Summary of Natural England's Written Representations advice in respect of A46 Coventry Junctions (Walsgrave)

Legend

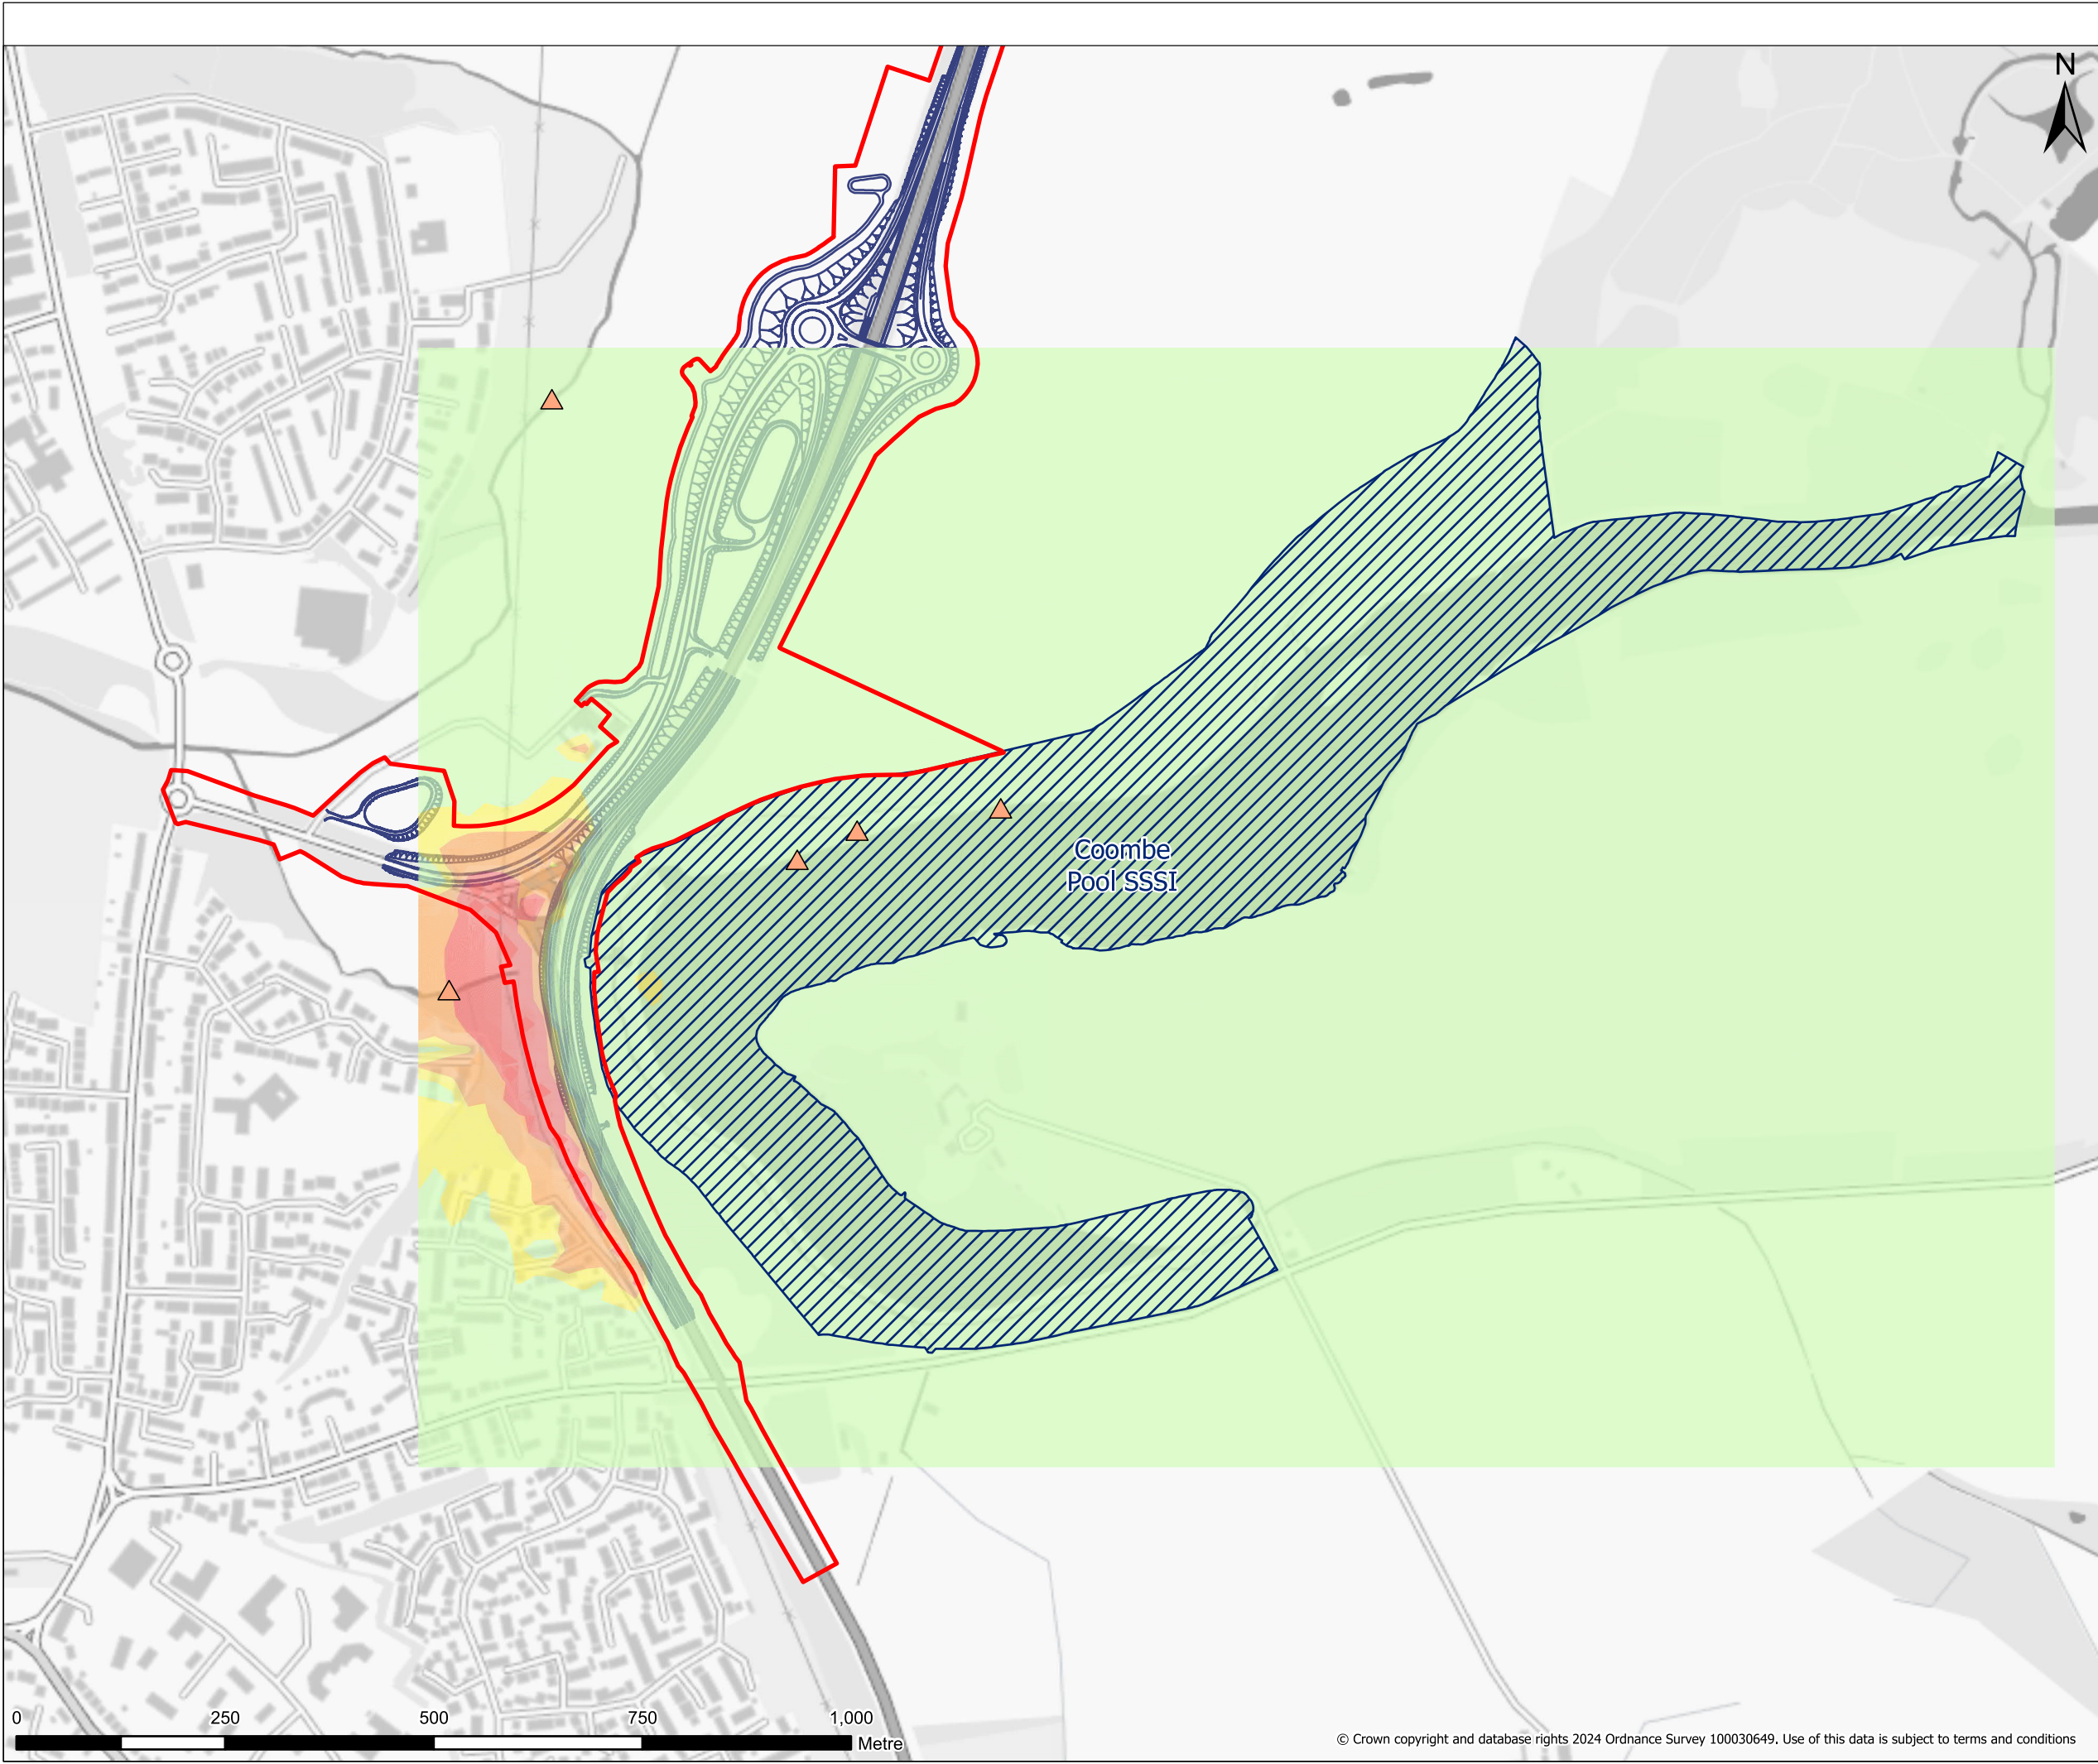
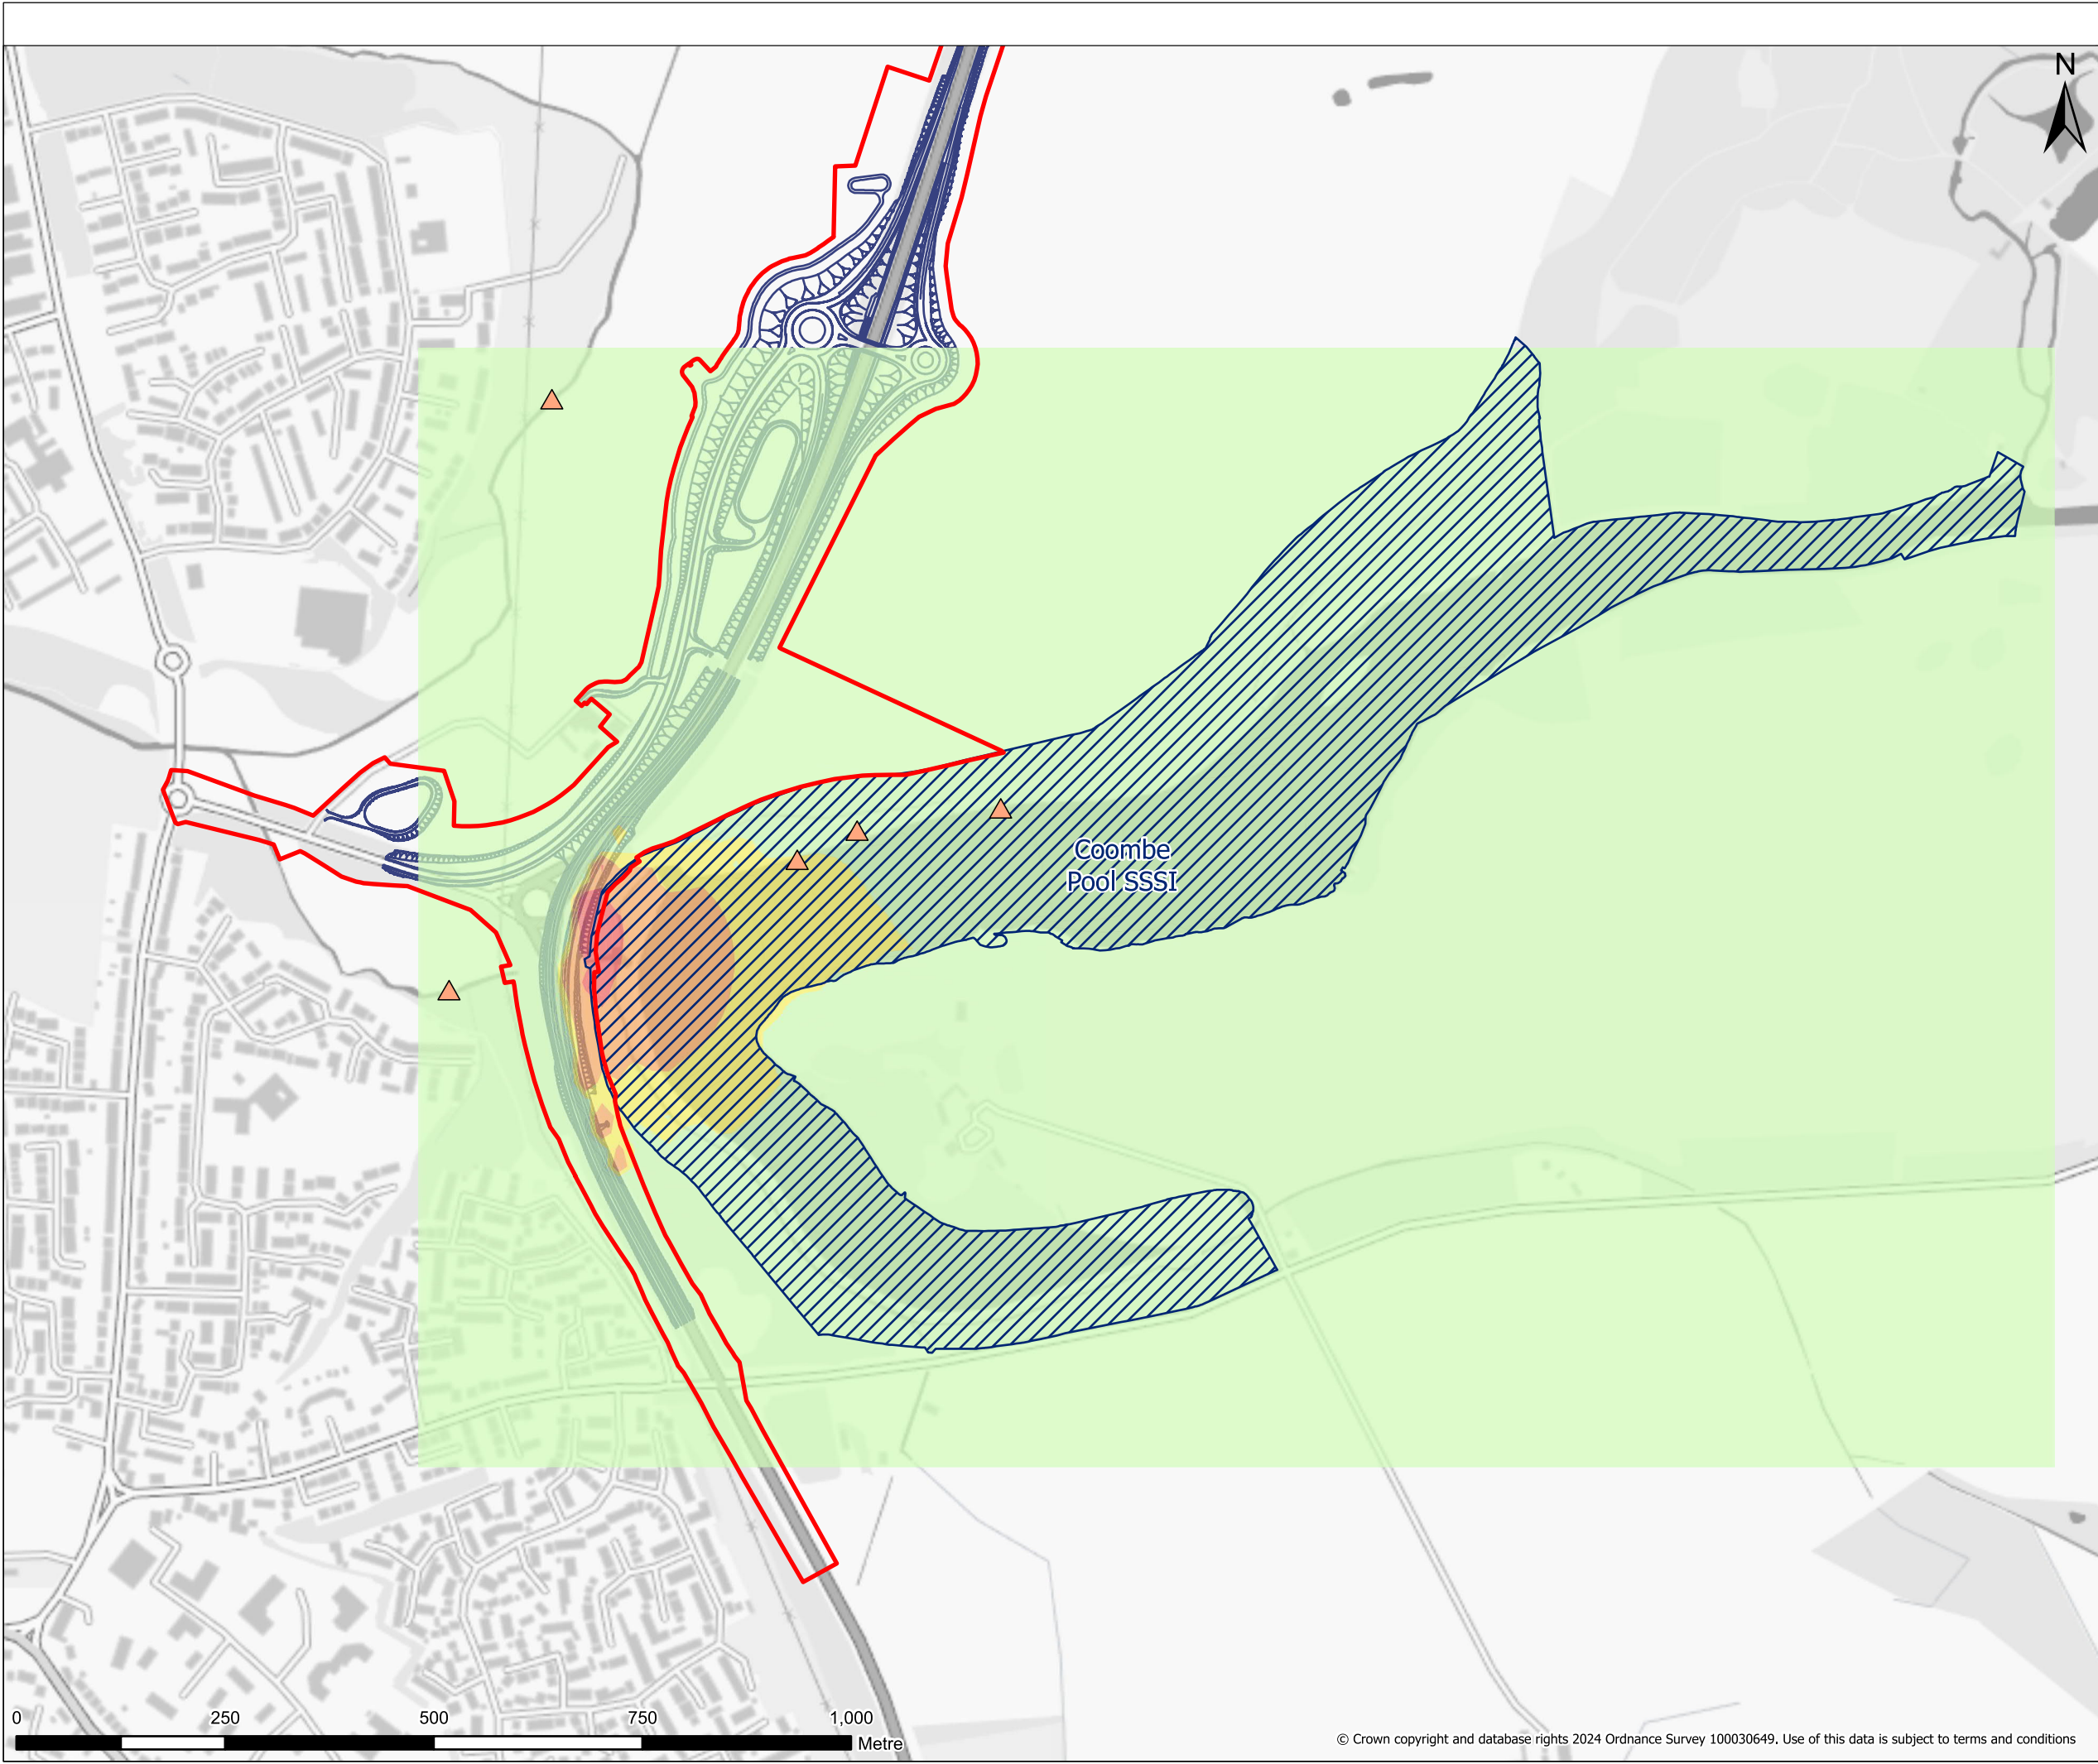
- Impacts of noise and lighting on Combe Pool SSSI and mitigation to prevent impacts (NE4).
- Impacts from air quality (NOx, NH3, N dep) on Combe Pool SSSI and Herald Way Marsh SSSI (NE6).
- Impacts on water quality and water quantity on Combe Pool SSSI and Herald Way Marsh SSSI (NE7).
